From: Michael Eastham <Michael.Eastham@arun.gov.uk>
Sent: 22 January 2020 13:04
To: Planning.Responses <Planning.Responses@arun.gov.uk>
Subject: FW: A/122/19/OUT - Land off Arundel Road, Angmering - Development Framework Plan

From: Sue Howell <Sue.Howell@arun.gov.uk>
Sent: 22 January 2020 12:08
To: Michael Eastham <Michael.Eastham@arun.gov.uk>; Joe Russell-Wells <Joe.Russell-Wells@arun.gov.uk>; Robin Wickham <Robin.Wickham@arun.gov.uk>
Subject: RE: A/122/19/OUT - Land off Arundel Road, Angmering - Development Framework Plan

Thank you for the revised Development Framework Plan CSA/3467/136 Rev F with amended foot/cycleway and Play facilities amended.

Figure 5.1: Development Framework Plan.

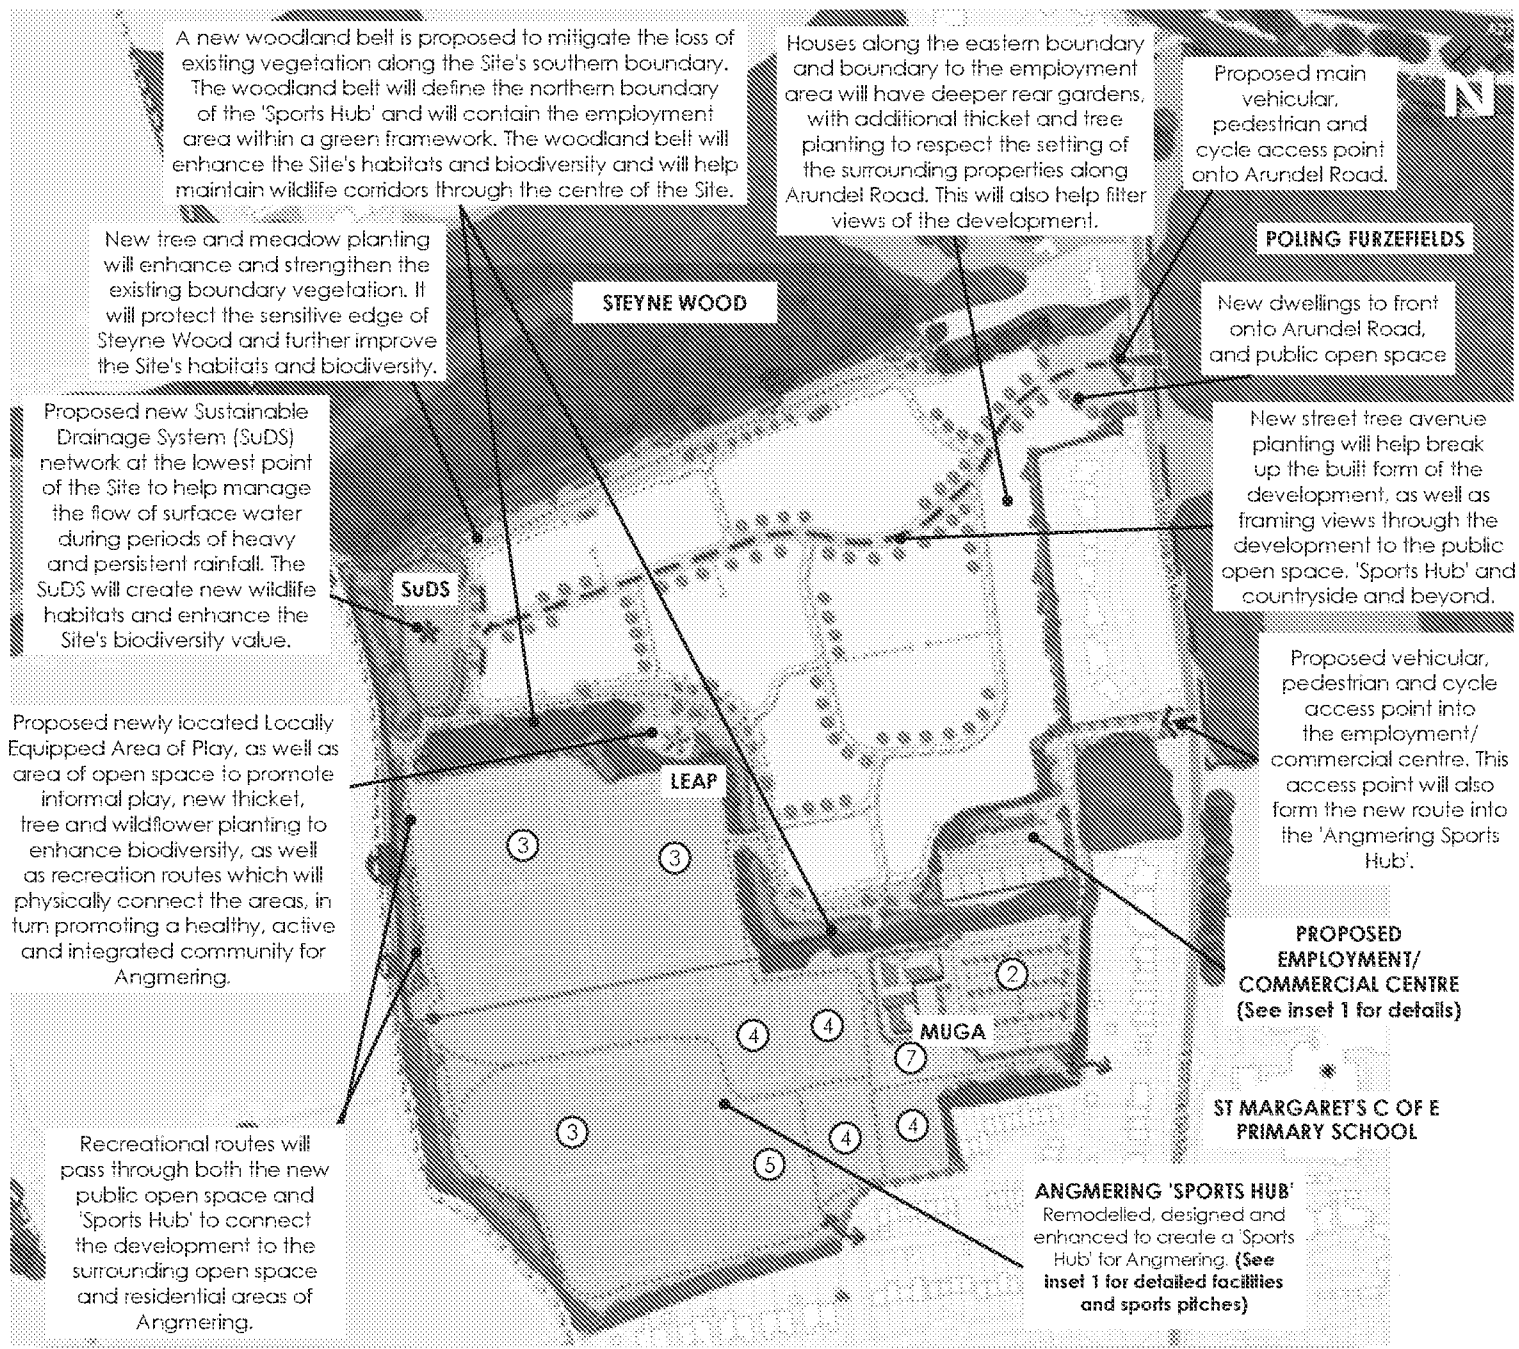
The relocation of the LAP to alongside the LEAP I don't necessarily agree is the correct location and I'm sure with a bit more thought at the detail stage a better location could be brought forward. I understand Sussex Police comment re location next to the access road, but mindful that a LAP is an unequipped area of natural landform/feature play aimed at the very young who would accompanied rather than an equipped play area. So I conclude happy to accept relocation in principal for the LAP with location to be determined at detailed layout/design stage further within the site.

LEAP I am happy to see centrally located within the development with the addition of offsite contribution into Palmer Road sports hub site.

Pathways and cycleways good to see that these have been given further thought and provide a good network within the site. It would be good to see these link with the wider network and for connectivity further into Angmering and I note the confirmation below re cycleway formation contribution. Regarding the existing Public Right of Way/Public Footpath which abuts the development and sports hub area, directly to the west of the site, I note the comment re access to this and third party ownership. I would still recommend that viability of connectivity to this be further explored particularly through the sports hub area as this would provide a valuable north and south link on this westerly perimeter of the proposals.

The previous iteration of the DFP showed a footpath only. We agreed this would be shown as a footpath and cycleway and noted that it would link into the wider Public Right of Way network. We can't however form the final connection point onto the PRow as this point of connection falls outside our land ownership and in the Palmer Road recreation ground -- the connection is reliant on the sports pitch/hub proposals being implemented and part of our land gifting. A footpath cannot connect from our Western boundary directly as there is an existing hedgerow that defines our legal boundary ownership, with a ditch in third-party ownership before the PRow can be reached. However, the £550,000 contribution towards a cycle route to Angmering village centre appears to address this concern directly.
